From: [Wolfenbarger, Jeanne](#)
To: [Dave Aube](#); [Brito, Russell D.](#); [Brian Nebel](#)
Cc: [Estevan CdeBaca](#); [Mark Wade](#)
Subject: RE: Fogo de Chao at Coronado Center (SI-2020-00050): Administrative Amendment Next Steps and Timing
Date: Tuesday, June 23, 2020 9:42:05 AM

Good afternoon, I visited the site today with Estevan. For the Administrative Amendment, the additional comments are:

SITE PAVING PLAN

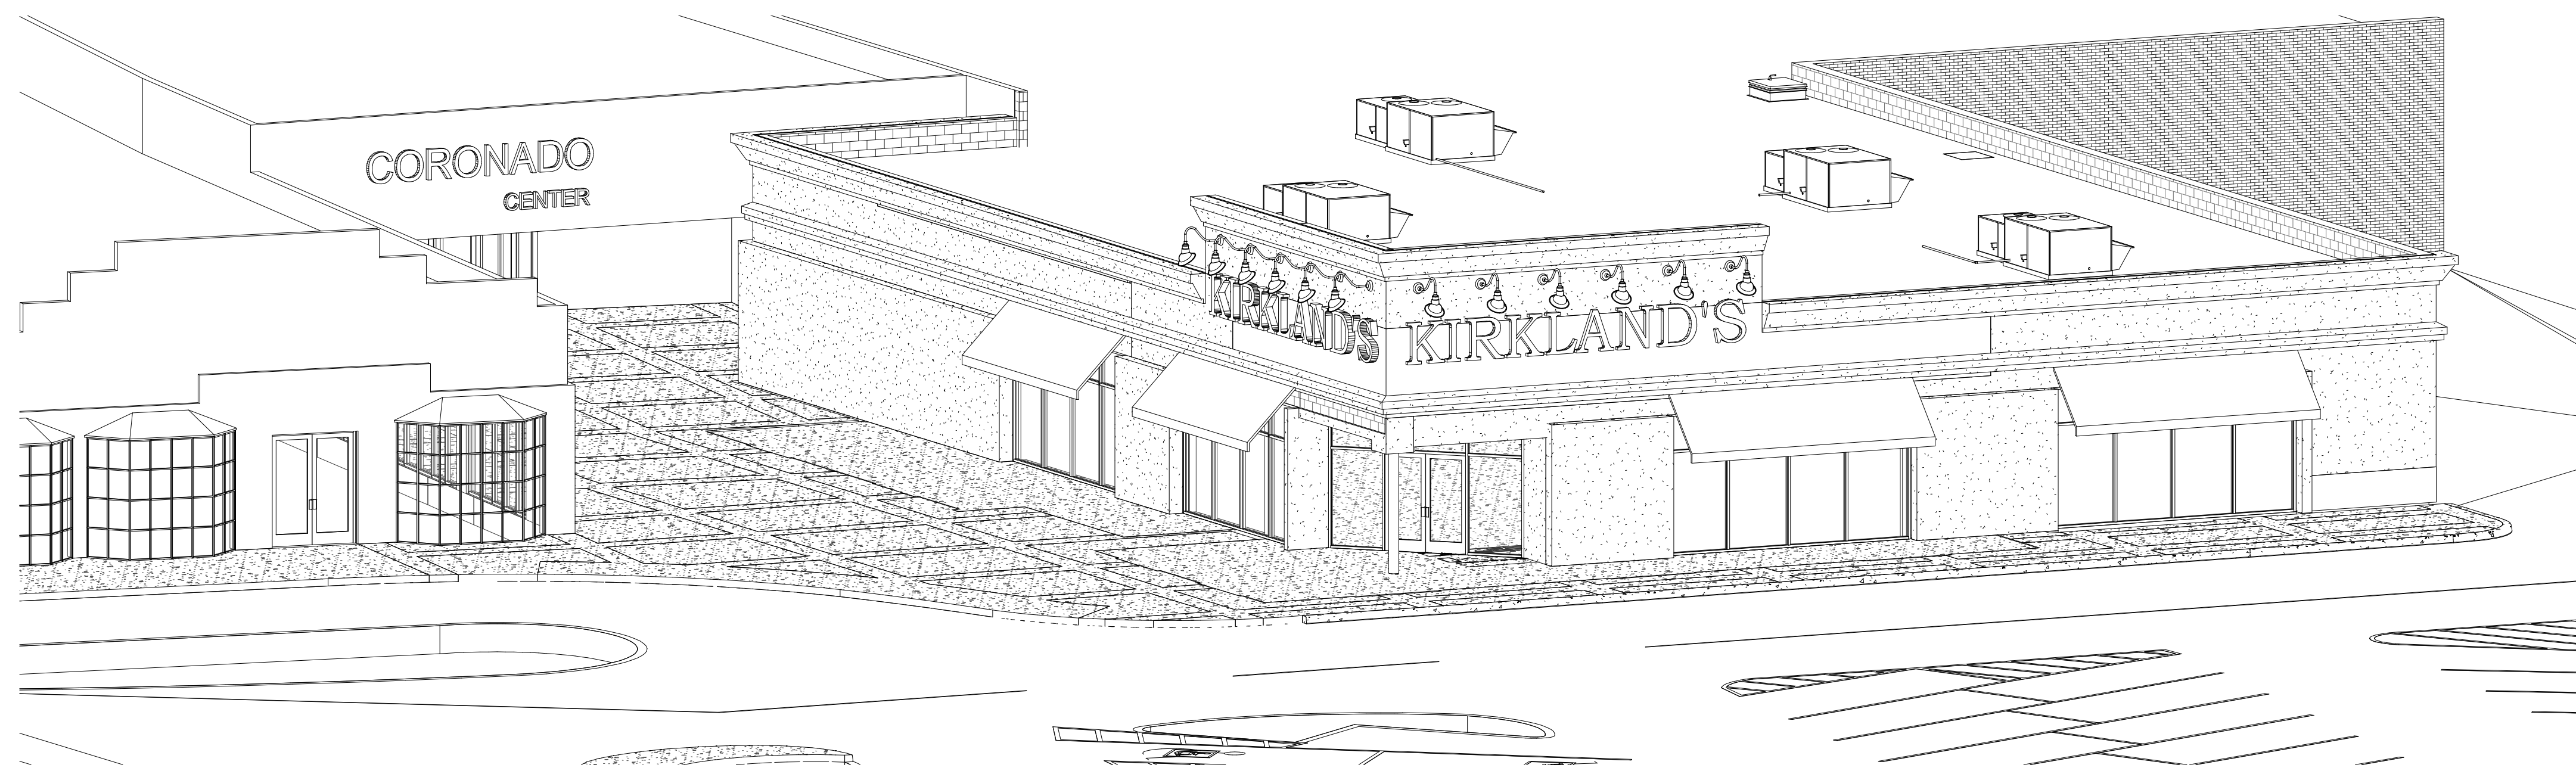
- Show existing crosswalk across parking aisle on the plans from the existing handicapped spots to the depressed curb area. **Crosswalk striping from the new ADA ramp at eastern entrance to the existing reserved parking stalls and the sidewalk along the entrance drive from Louisiana has been added plans. P**

- On the site plan, clarify keyed note 20 at the end of the crosswalk for the ramp. If the ramp is drawn graphically on the site plan, and it lines up with this existing crosswalk, this will complete the ADA connection at this location. **Keyed note language has been clarified. Essentially the ADA ramp is about 37' long and has wings transitions on each end. This seemed like the best condition to allow for patron to be dropped off along the curb.**

- For valet drop-off parking, ensure that this area **does not conflict with the existing crosswalk**. Place dropoff parking area and signage at a point to the south of the crosswalk where two vehicles can drop off without blocking the crosswalk or the main traffic trying to get back out to the accessway that ties into Louisiana Blvd. **A site plan will be provided with the Fogo De Chao plans that identifies the areas that are to be designated as valet dedicated parking. We were not provided with specifics of the Valet podium, to show on the plans, but this will be added by the Fogo de Chao design team.**

- Paint new bollards yellow along the new curb. **All bollards are Stainless Steel to match the remainder of Coronado Mall. This was requested by the management team for Coronado. Since this is a private driving lanes, and parking condition, we would like to request keeping the bollards as stainless steel.**

- For the ramp designated as Ramp C further to the north, it would be preferable to not have this as header curb as this may present a tripping hazard. (The existing ramp here at this location does not have header curb, and the slopes on it are quite acceptable.) However, if leaving this ramp as is, depending on the grading plan, have the header curb for the ramp painted yellow. **We would prefer to keep the header curbs, as adding winds will reduce the amount of landscaping available. Keyed Note #22 called for the transition of curb heights to be painted yellow to identify the hazard.**

- Specify a maximum 2% slope for all pedestrian paths as part of a general note on the site plan. **Sheet note I has been added to ensure that slopes are less than 2.0% on all new sidewalks.**

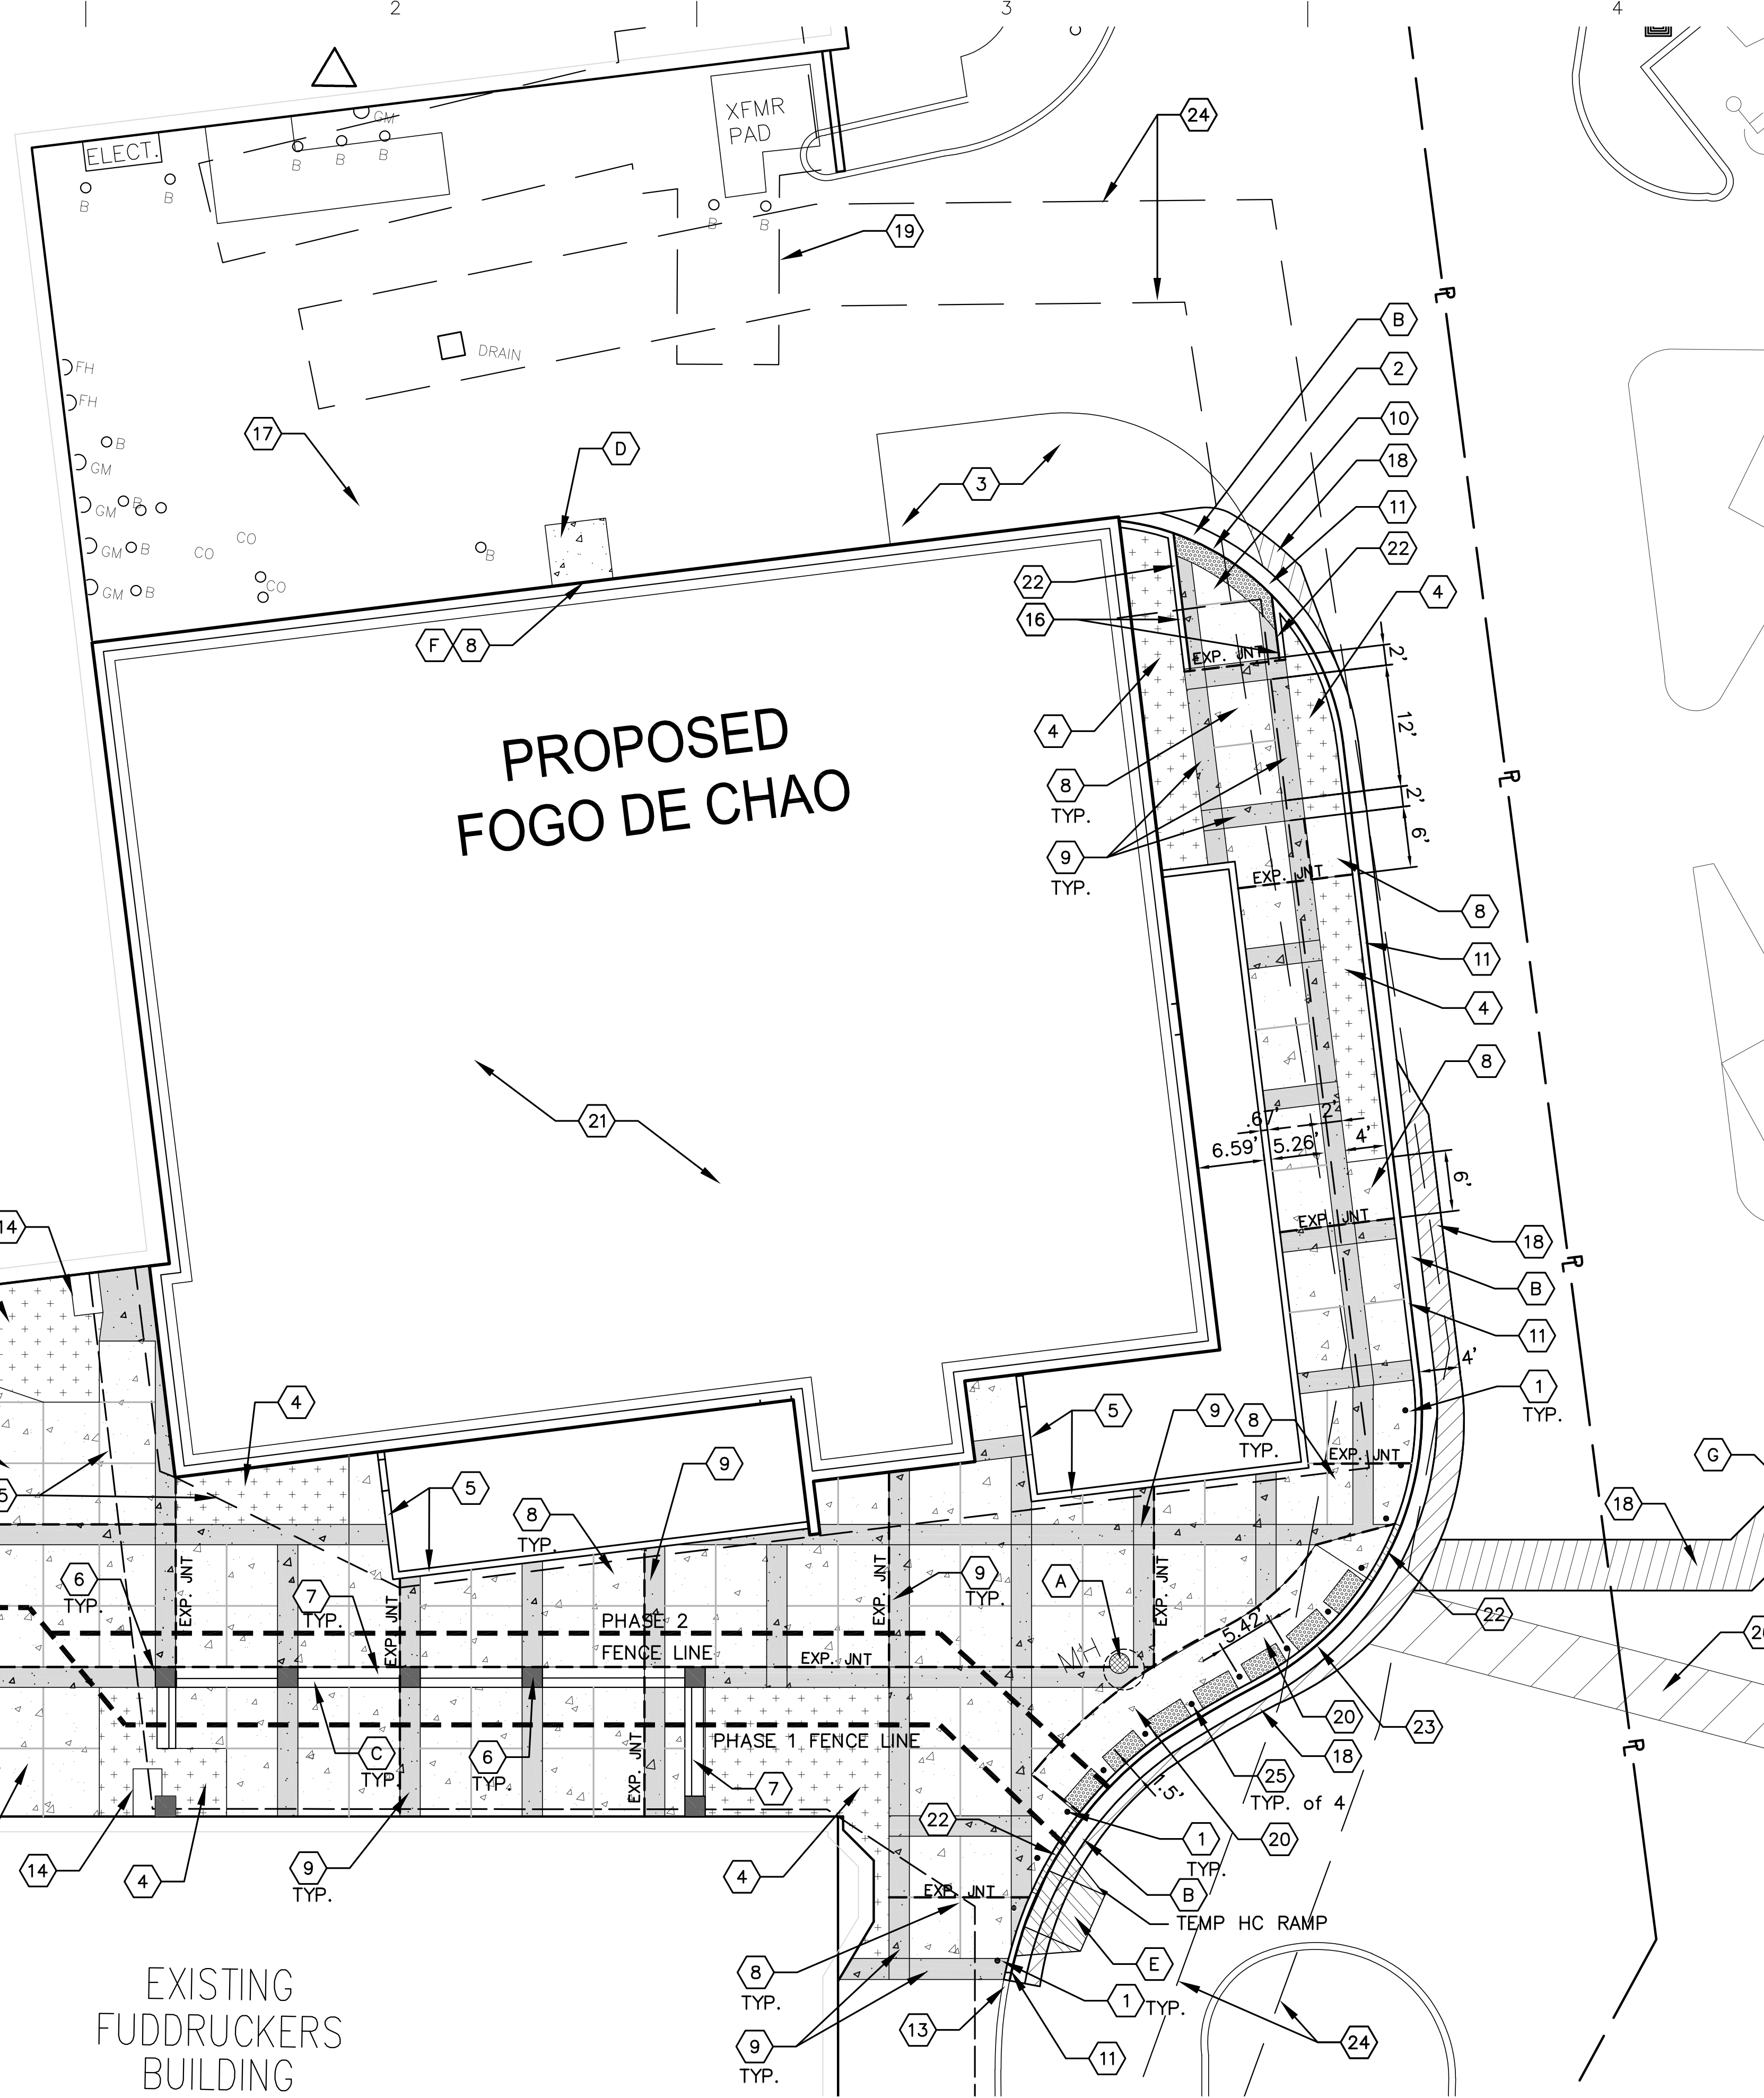
Is the area where the bollards are located going to be well-lit because I am concerned about these getting hit?
